Application for removal or variation of a condition following grant of
planning permission. Town and Country Planning Act 1990.
Planning (Listed Buildings and Conservation Areas) Act 1990

Number	114
Suffix	
Property name	
Address line 1	Copse Wood Way
Address line 2	
Address line 3	
Town/city	Northwood
Postcode	HA6 2UB

Single storey rear extension, conversion of garage to habitable use and conversion of roofspace to habitable use to include 2 rear dormers, 2 front rooflights and a side rooflight with alterations to fenestration.

15807/APP/2020/2995

rev:	date:	description:
scale:	1:100	A1 date: 17 / 09 / 2020
drawing no:	1356 / P / 3 ^B	drawn: TF
drawing:	HOUSEHOLDER APPLICATION PROPOSED FLOOR PLANS & ELEVATIONS	
project:	114 COPSE WOOD WAY, NORTHWOOD, HA6 2UB	
client:	MR AND MRS POPAT

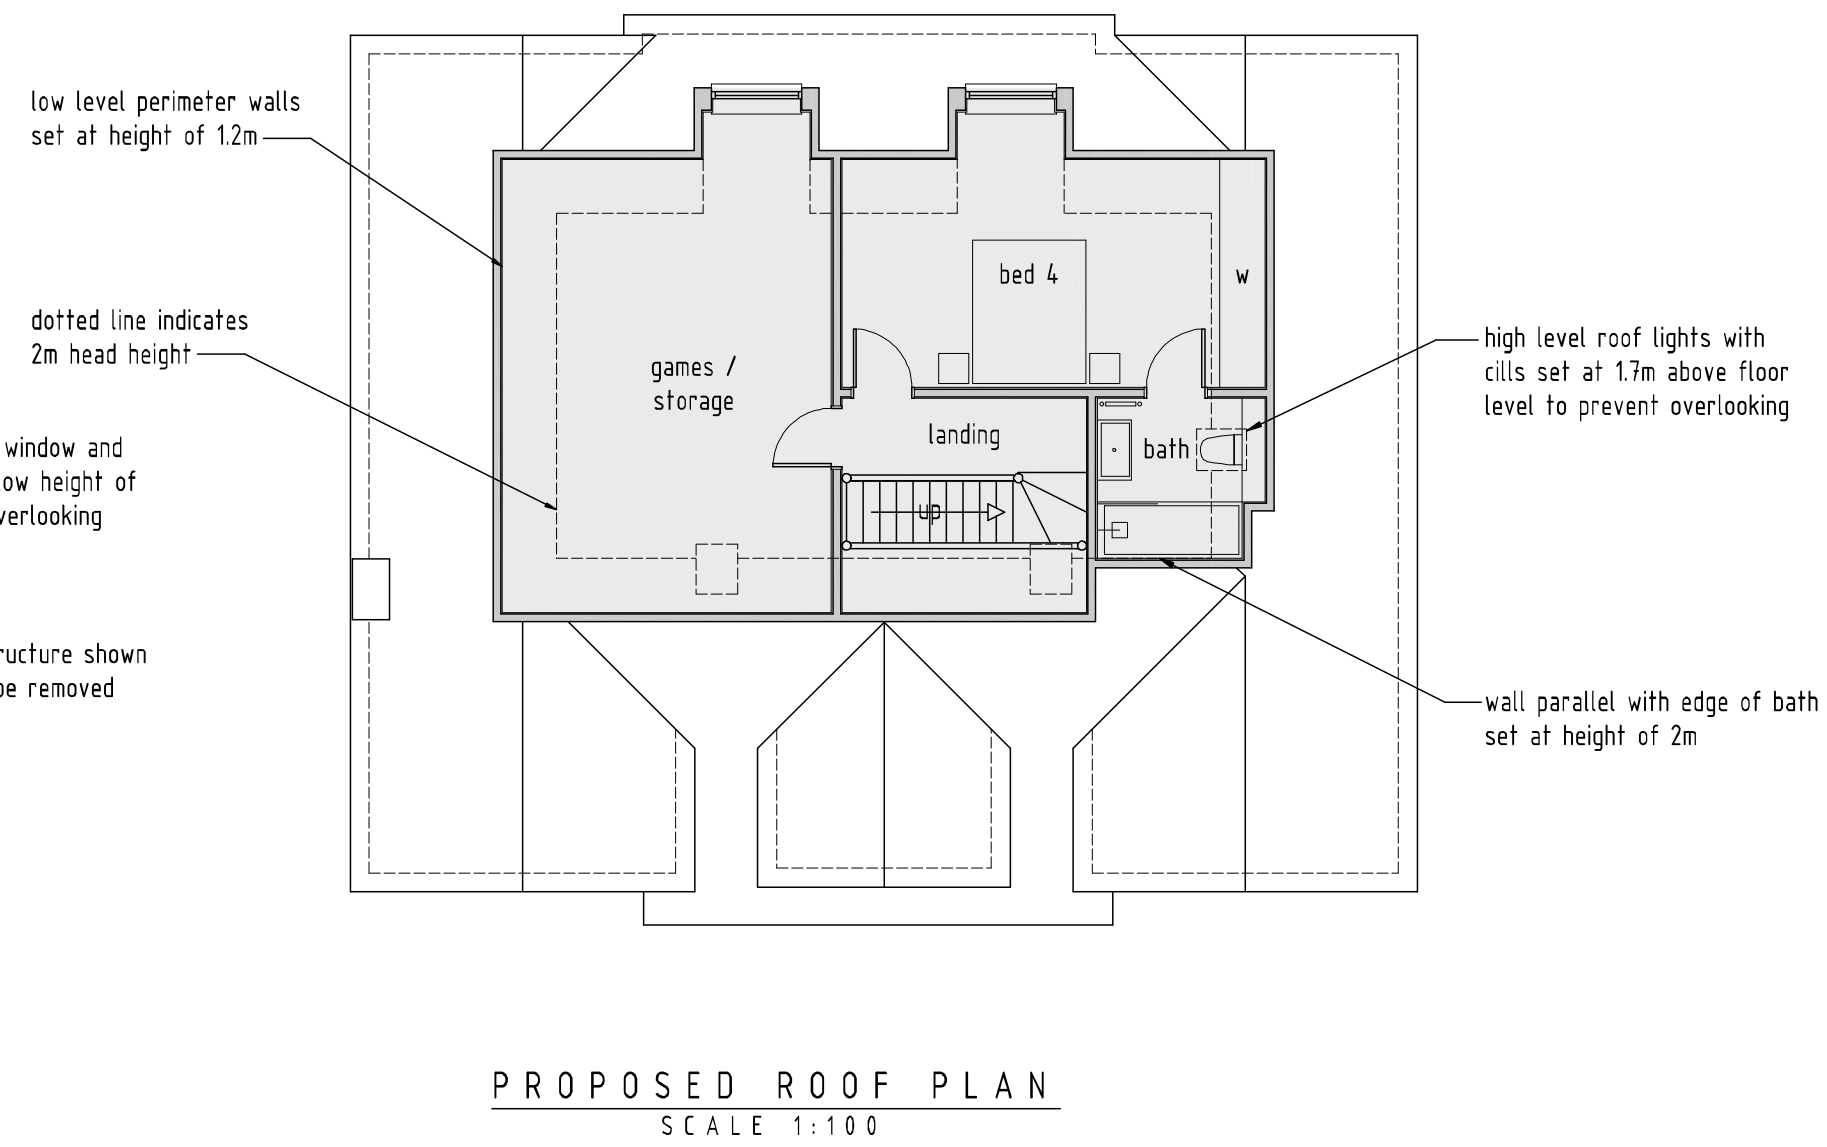
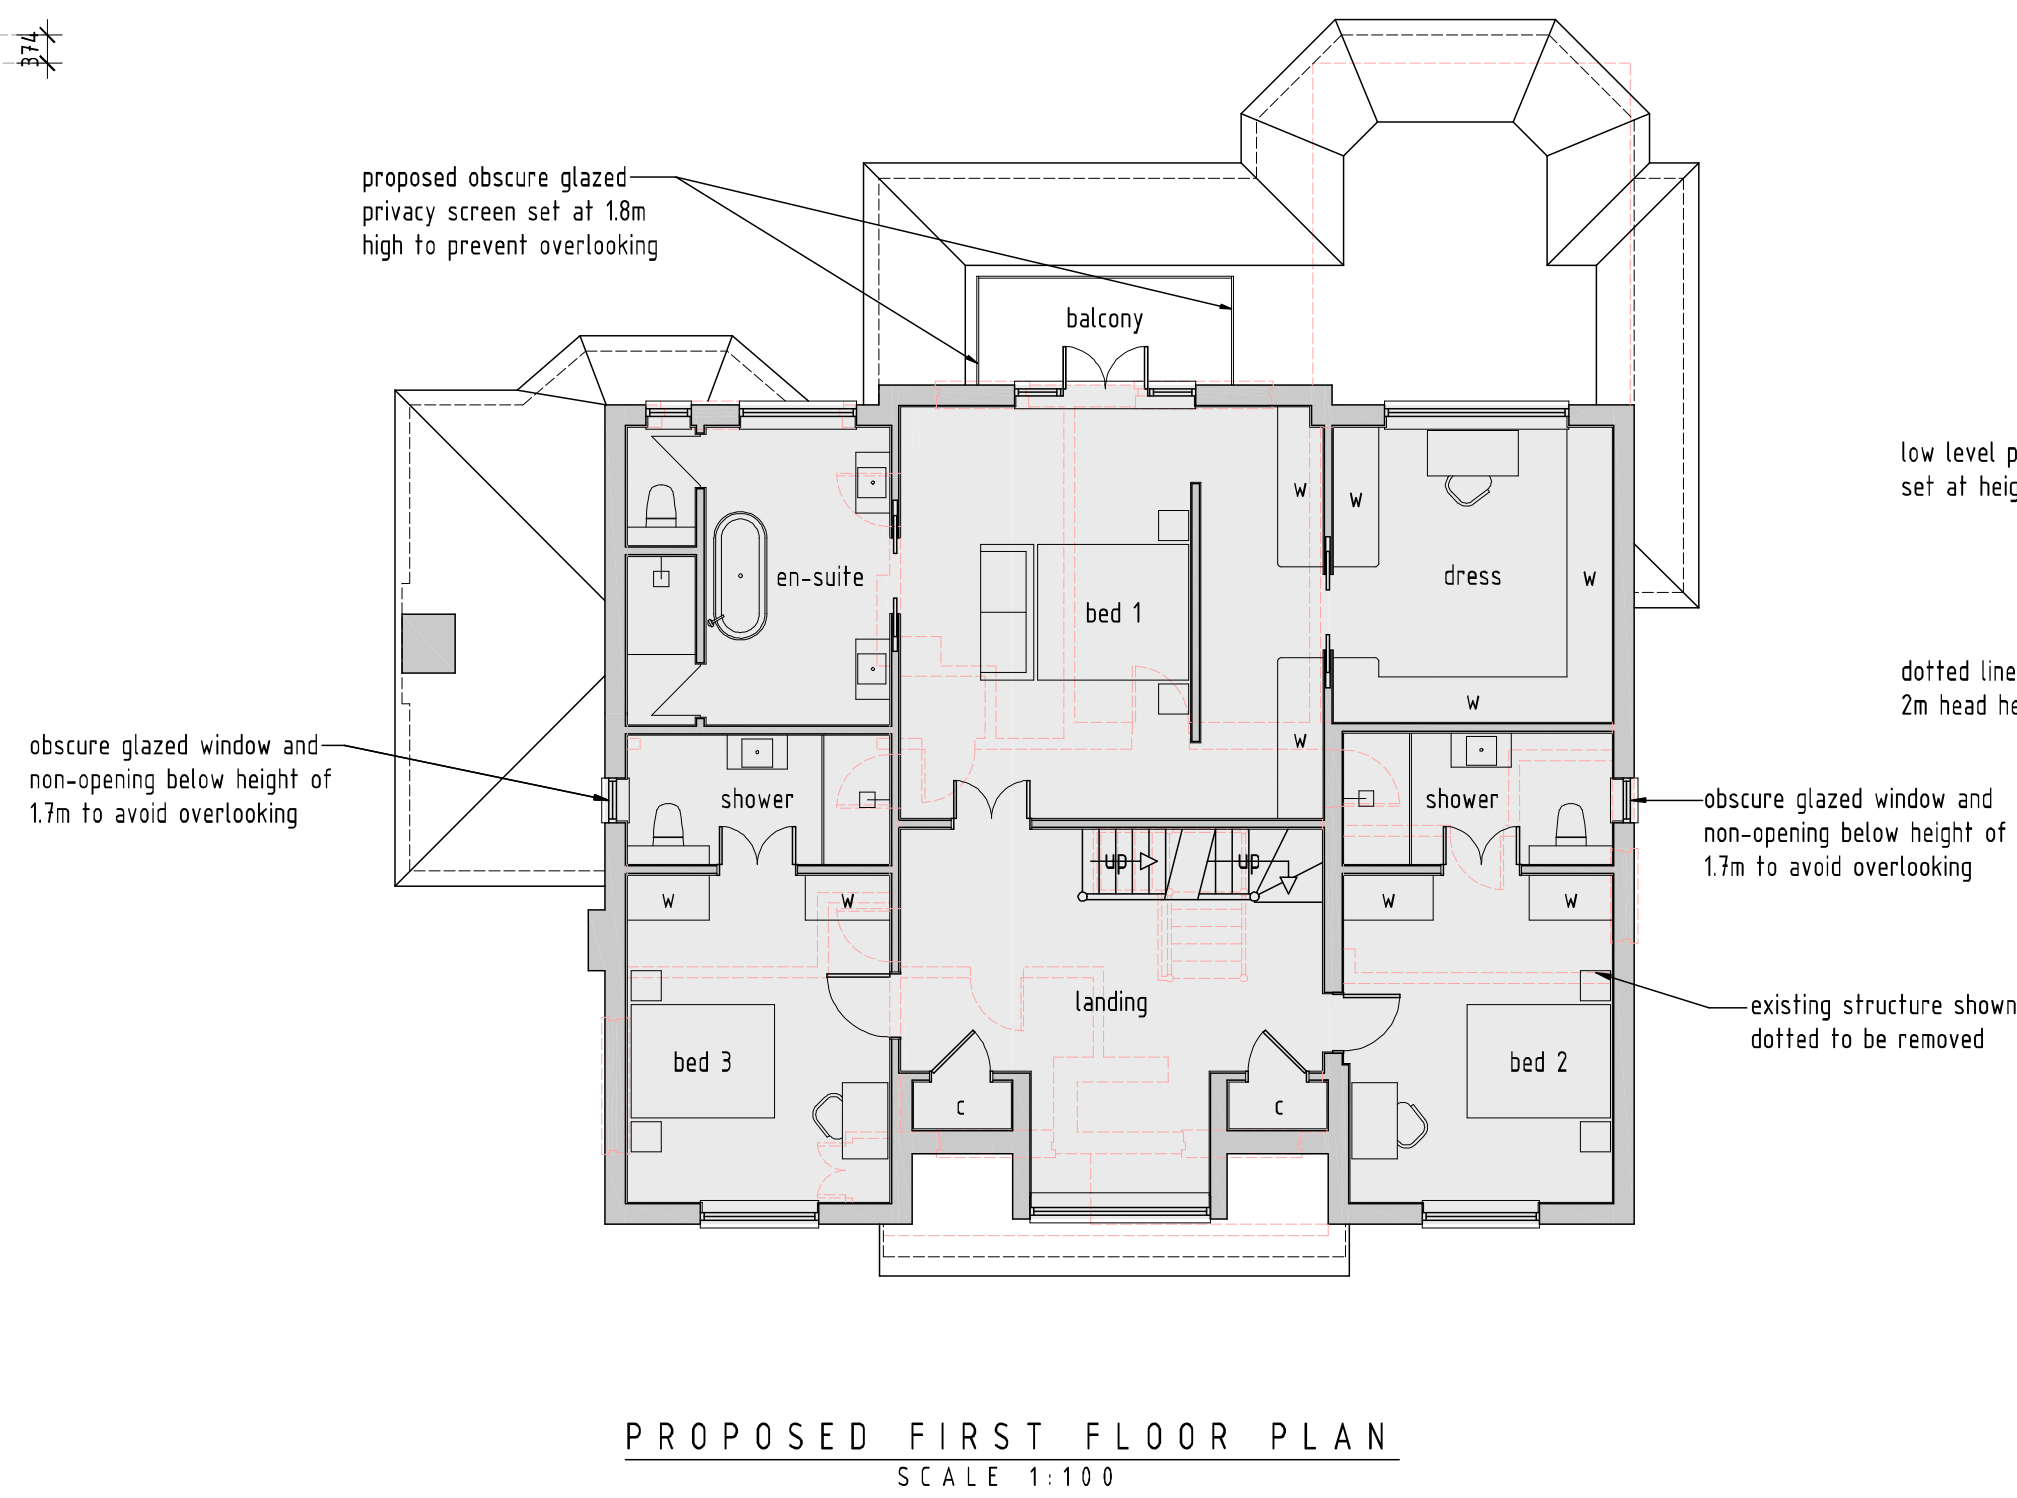
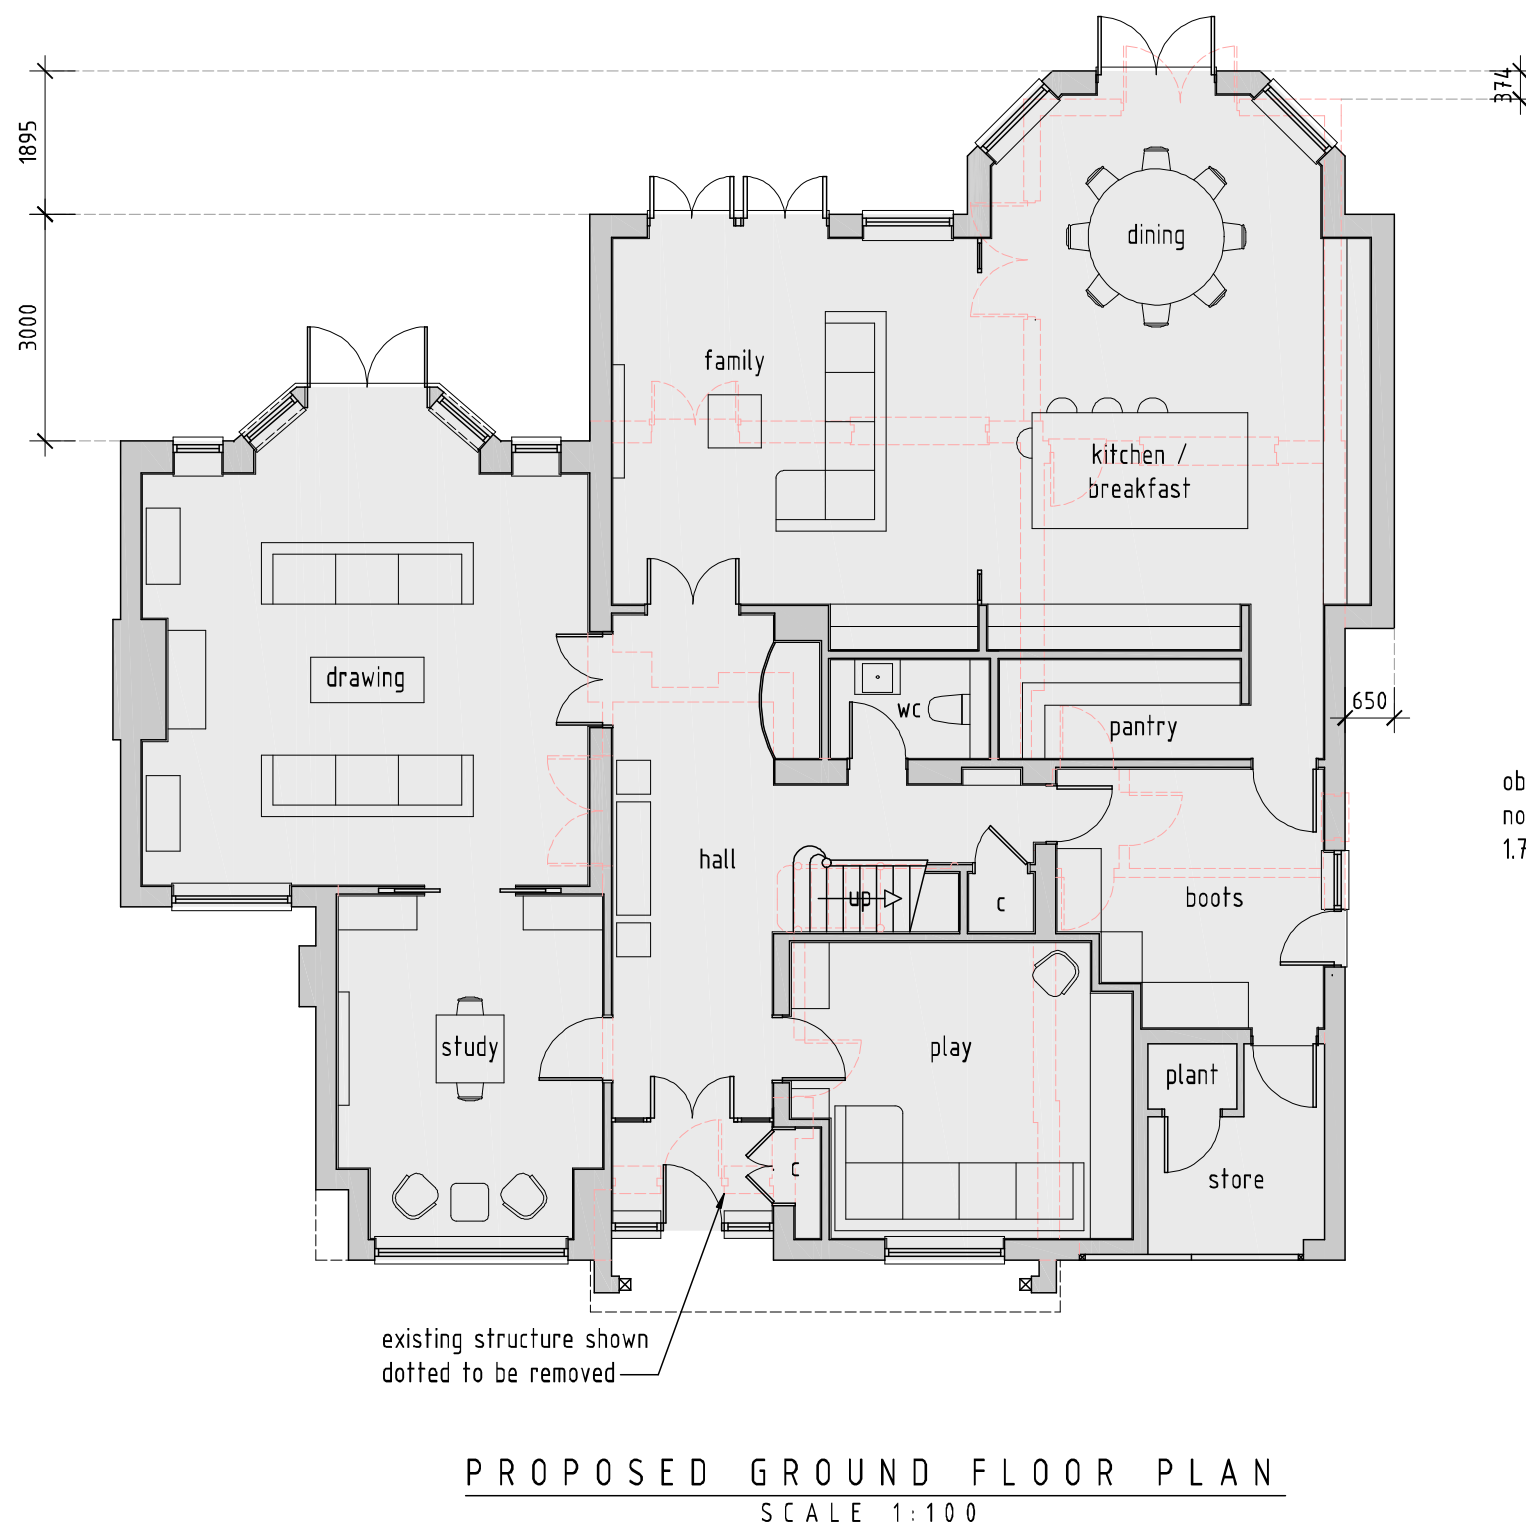
To allow for the changes to the porch / roof, front dormer and rear balcony.

Replace the approved drawings 1356/P/1A and 3A with the new drawings 1356/P/1B and 3B.
